PLANNING RATIONALE ADDENDUM #1

Fotenn Consultants Inc. (Fotenn) has been retained by Minto Communities (Minto) to submit and monitor a Zoning By-law Amendment and Draft Plan of Subdivision applications for the lands municipally known as 936 March Road in the Kanata North community of the City of Ottawa (subject lands).

Figure 24 Local Road (Typical 16.5m ROW)

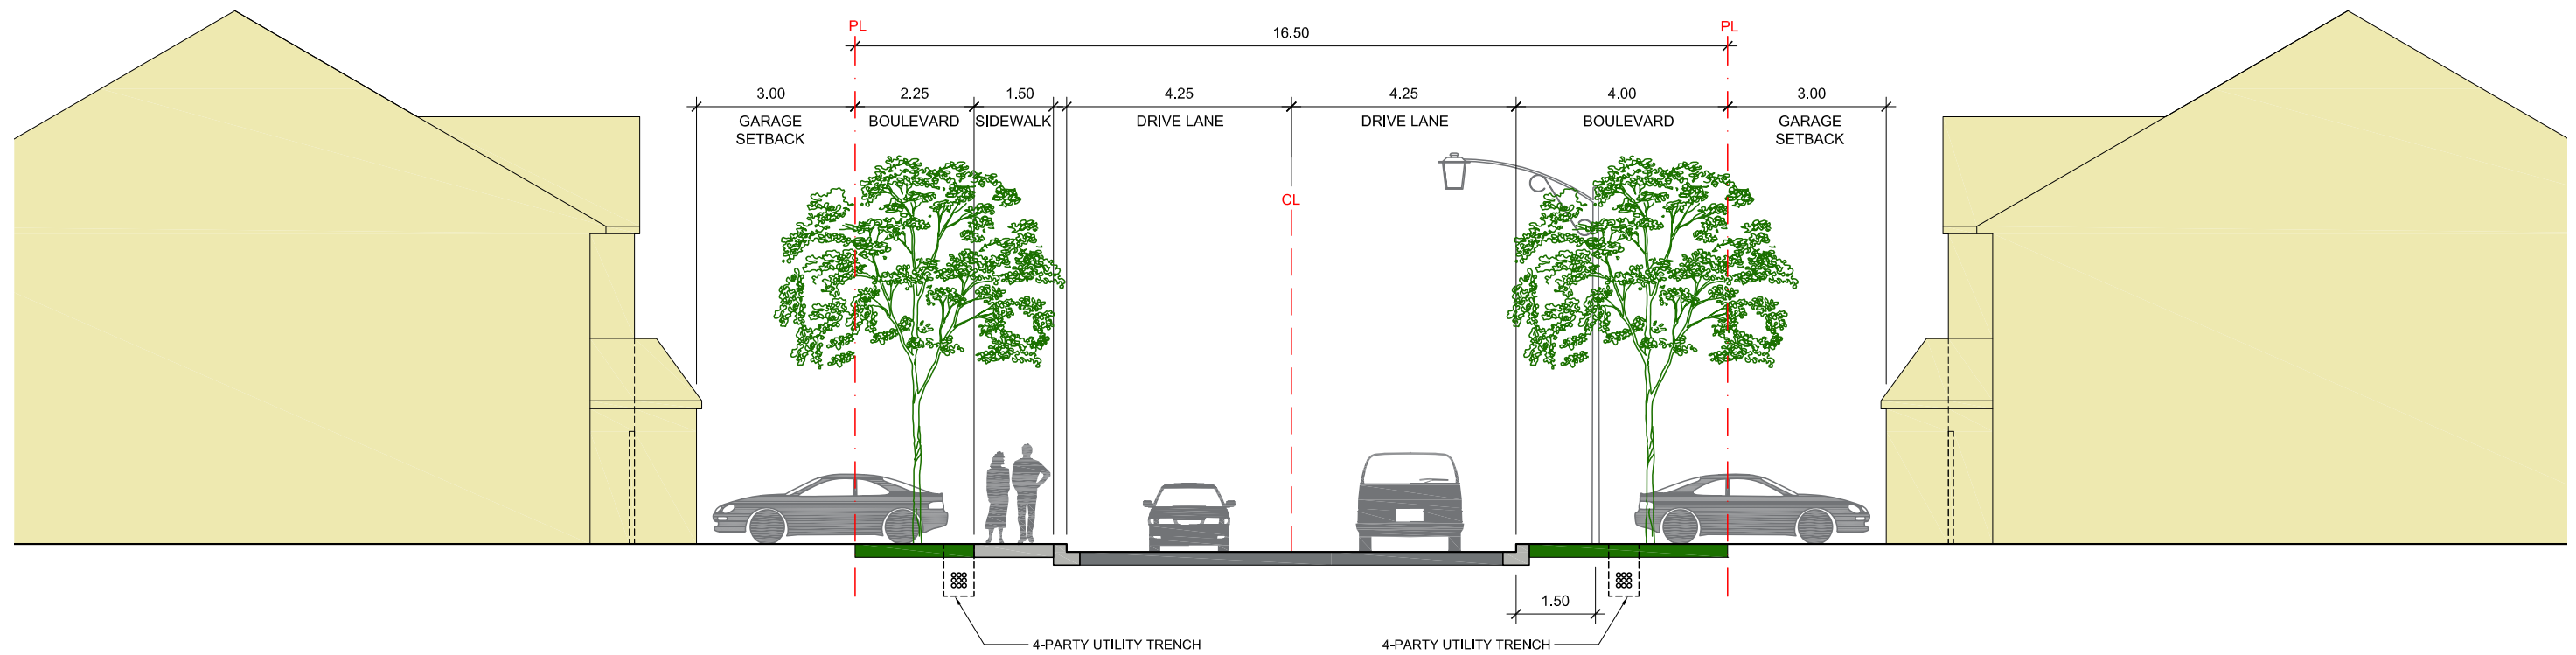
Concerns regarding use of the 16.5 m r.o.w throughout the community. The allowance for 16.5 m r.o.w is a consideration for extenuating circumstances; the local roads in Kanata North are intended to be 18 metres.

The use of the 16.5m rights-of-way (ROW) have been implemented throughout the community based on success in other subdivisions around the City. More specifically, the 16.5m ROW would serve three (3) functions for the Minto Subdivision:

The reduced ROW width allows the subdivision to develop in a manner that would increase project density by creating shallower lots of 26 metres and allowing for a more intensive use of land, along with a greater number of units on the lands, helping the development increase density and unit types, and meet the density standards set out in the KNCDP.

The property has several constraints, including the environmental constraints from the creek, along with the irregular configuration of the property. The reduced ROW would allow Minto with some flexibility in increasing the total number of units and to account for the land constraints while developing the lands and providing the required school and park blocks.

The Minto Plan of Subdivision complies with the urban design objectives and is compliant with the policy directions of the CDP and the Building Better and Smarter Suburbs guidelines, including a modified street grid pattern. The CDP stipulates that “reduced right-of-way may only be considered where soil conditions will permit planting of street trees within the reduced right-of-way” Minto has accounted for this and will be exploring the possibility of street tree plantings in the reduced ROW.

The reduced 16.5m wide ROWs are not an attempt to market and allow for a larger, suburban product but rather to provide a product consistent with the small lot size, increase project densities and meet the design directions set out in the KNCDP.

Drawing file: plan / All_Image Referencing_Subdivision_Image Reference_2019-09-17 Concept Plan D07-16-18-0032.PDF

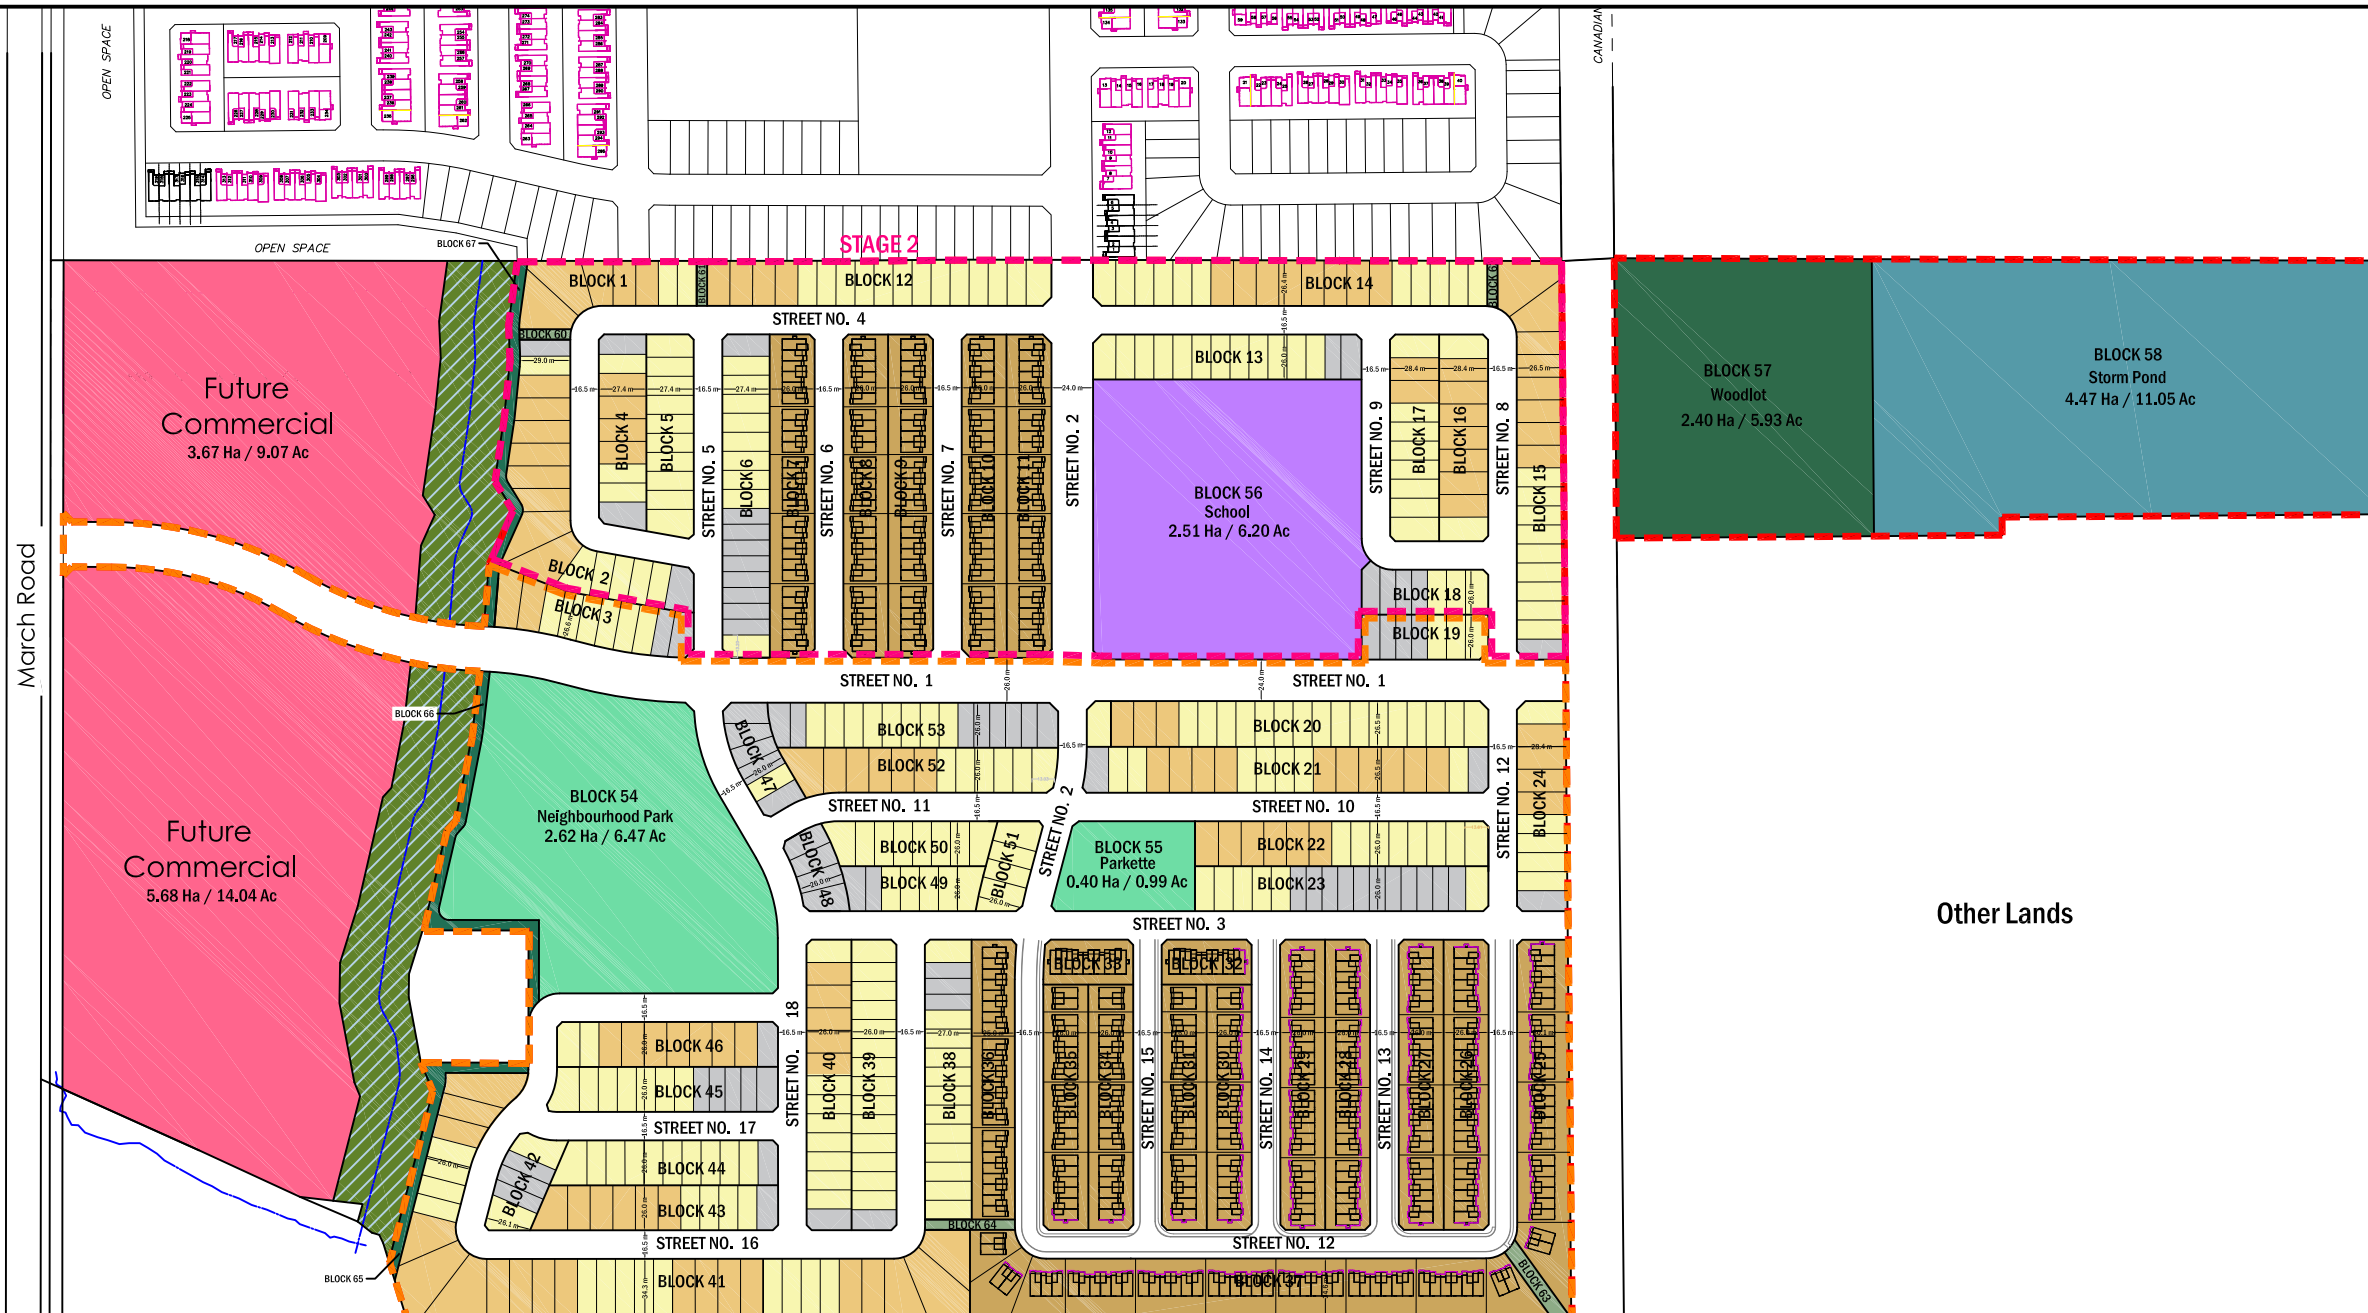
Please include some residential multi-unit block (in addition to townhomes) within the subdivision, ensure that the total breakdown meets the minimum density of 36 units per net hectare (not 34), and contain at least 30 percent single and 10% apartment as per the Official Plan policy 3.6.1 (14). Please revise the planning rationale to reflect the change.

Please include a proposed zoning map, including a chart listing the corresponding blocks and lots on the draft plan.

The creek corridor and woodlot should be zoned EP.

Inclusion of BLK 61 as a park block does not conform to the Kanata North CDP, please include a paragraph in the planning rationale that explain this deviation.

The revised plans now reflect a minimum density of 38 units per net hectare, meeting the density targets contemplated in the Official Plan. The Plan of Subdivision generally reflects the Kanata North CDP Demonstration Plan and includes 420 townhouse units, defined as “multi-unit residential” in the CDP. As per section 4.3.2 in the KNCDP, the multi-unit residential designation has been defined as traditional townhouses, stacked and back-to-back townhouses along with low-rise apartments, contributing to the mix of uses in the area. While this Plan of Subdivision does not contain plans for multi-residential dwelling units such as apartments, there exists opportunities elsewhere in the expansion area to accommodate this built form, which would be more compatible with the neighbouring planned context.

Please see Appendix A for a zoning map of lands.

The creek corridor and woodlot have been identified on the corresponding zoning map as EP.

The addition of Block 61 (now Block 474) (a Parkette) deviates from the CDP by providing additional parkland for the residents of the subdivision. The addition of this block is intended to provide residents better access to parkland within their community, particularly for the townhouse units in the immediate area. While there exists many opportunities and connections to the larger Neighbourhood Park and wood lot, the Parkette functions as a recreational space in closer proximity to the surrounding dwelling units. It is of our opinion that, despite the deviation from the CDP, an additional Parkette would be well-received by the neighbouring residents and would serve the broader community.
